Single storey side/rear extension, part two storey rear extension rear extension, raising of roof height to create a second floor and front double garage.

56 Angmering Lane East Preston Littlehampton

*Planning application - EP/37/20/HH
56 Angmering Lane, East Preston*

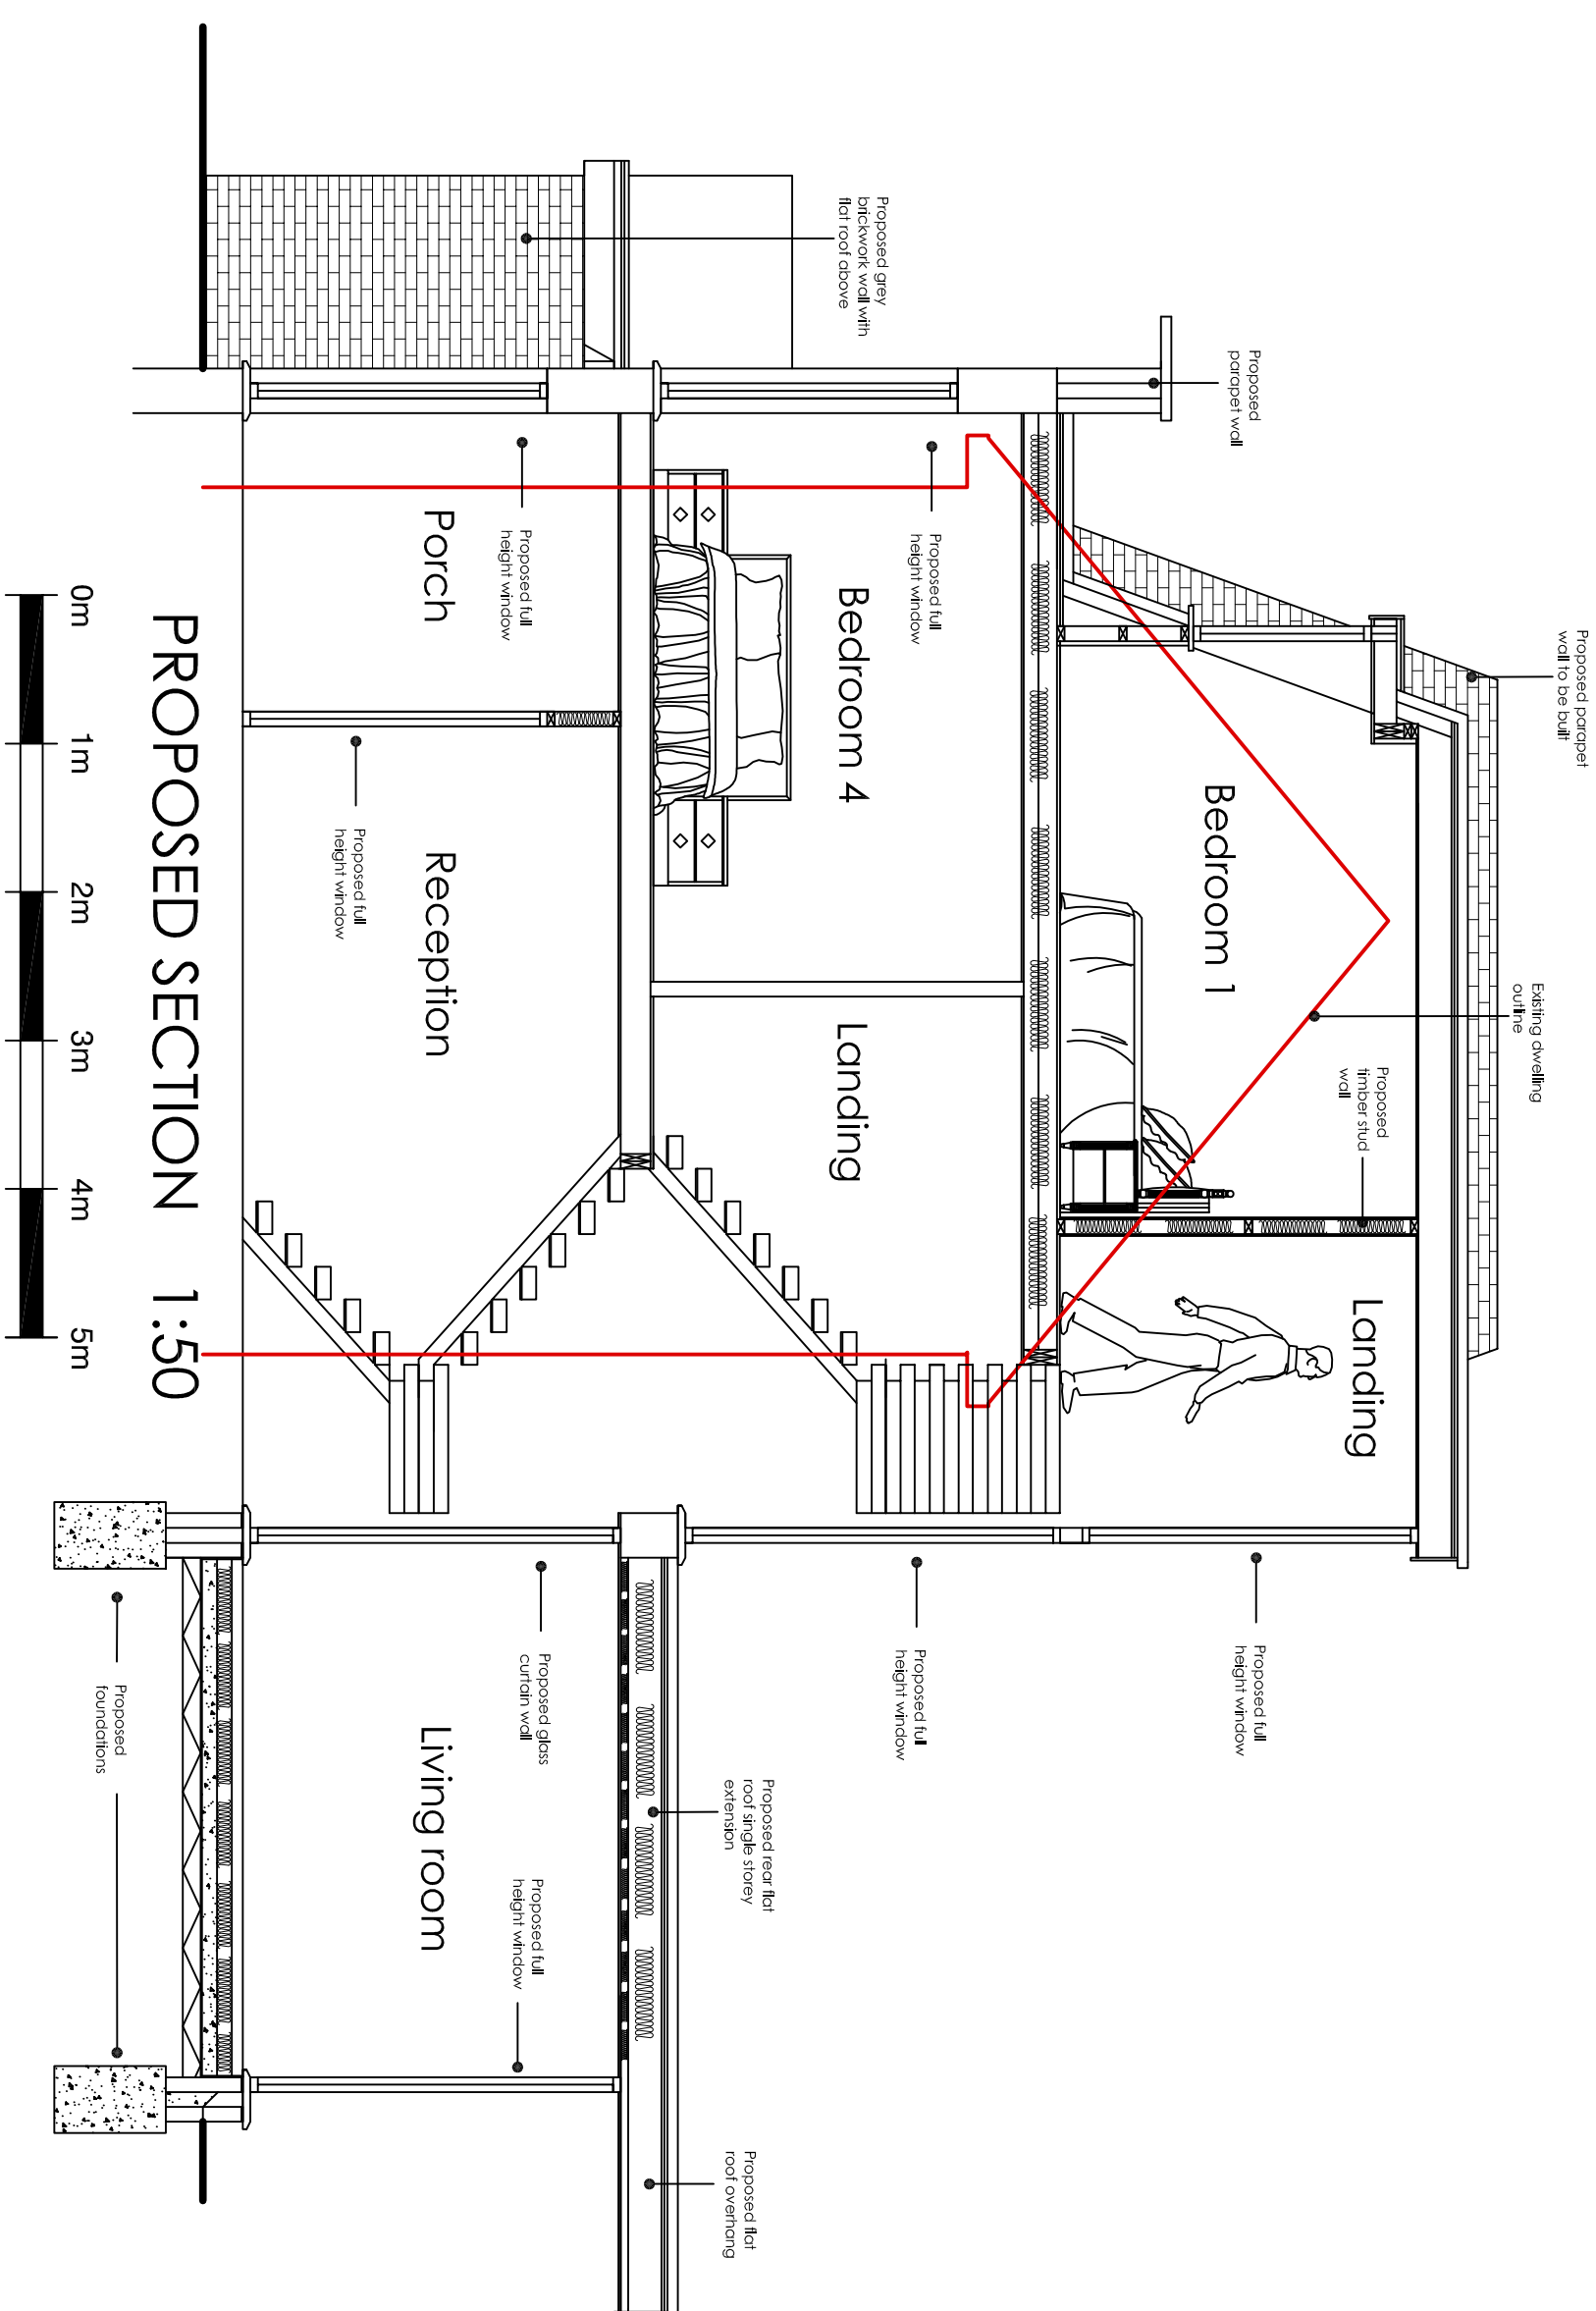
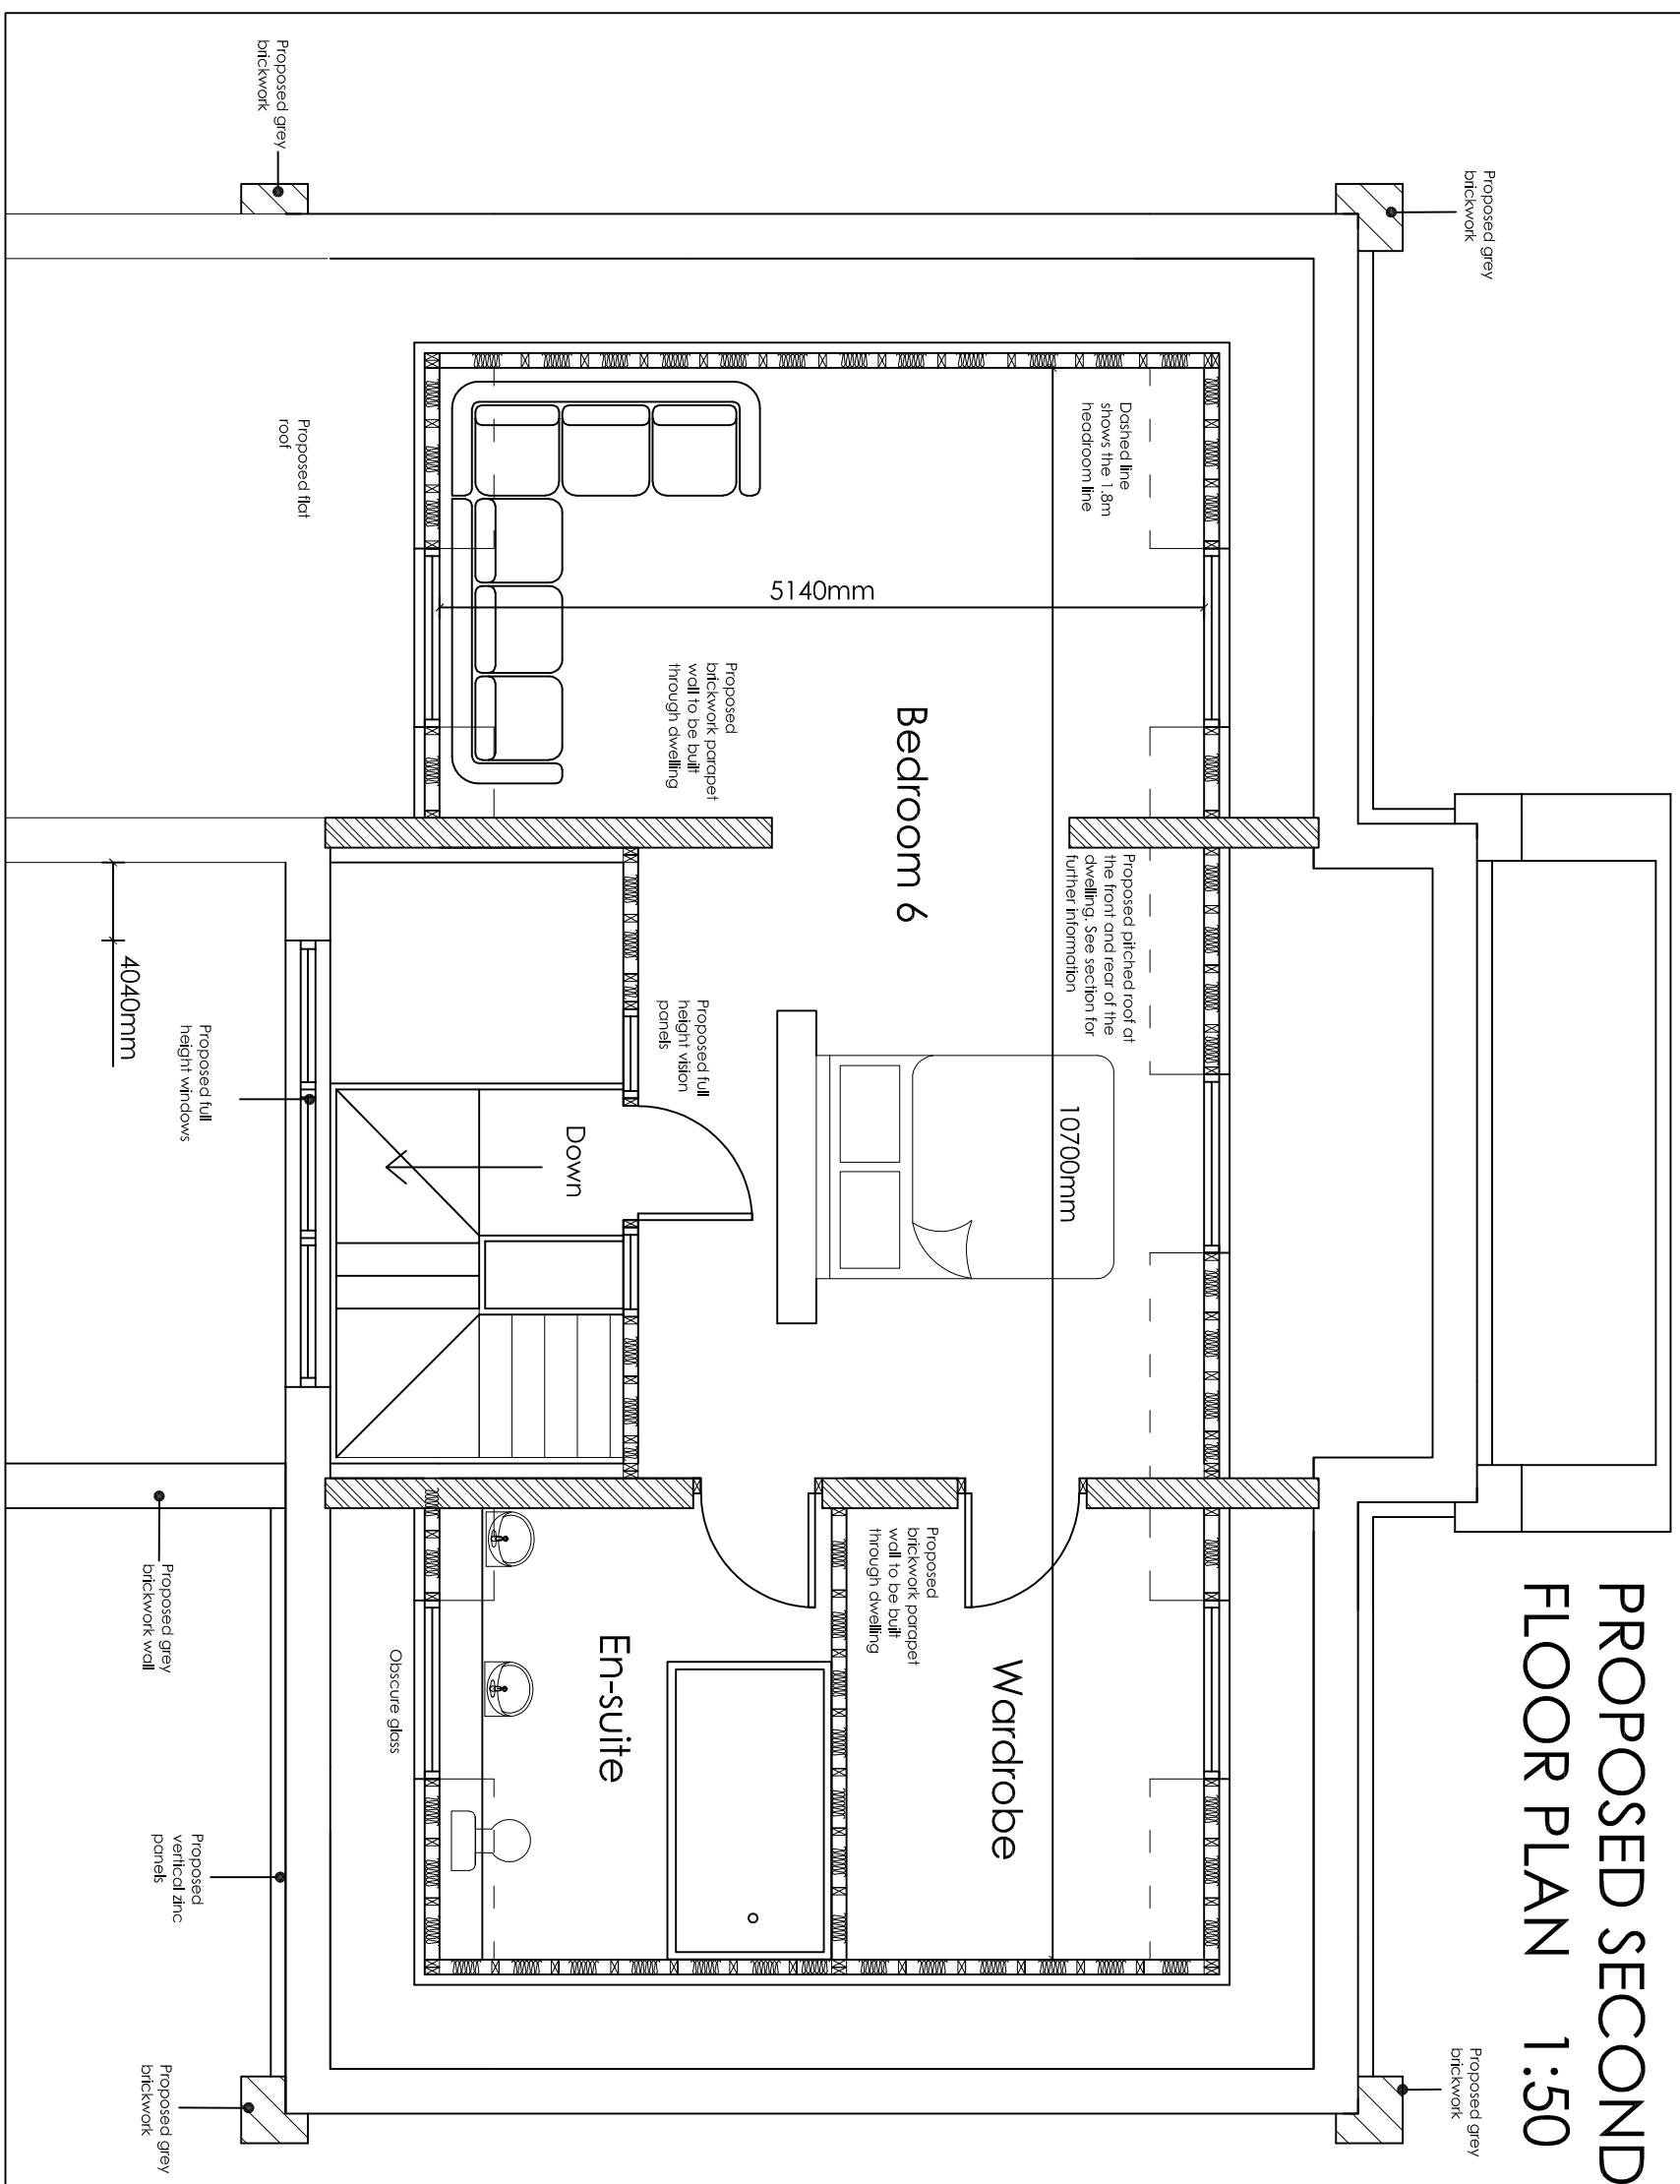
By changing from a traditional pitched roof style with two storeys to a three-storey flat-roofed property, they would in effect be creating something that resembles a small block of flats, which would be out of character with the remainder of the estate. In addition, the windows on the upper storey would overlook our house and garden, thereby directly impacting on our privacy and that of our other neighbours.

The plans also show that the garage would be much closer to the road than any buildings on the adjacent properties, which would detract from the general visual integrity of the street. The overall impression from the road is of houses set well back, within their own grounds and the current application would negate this.
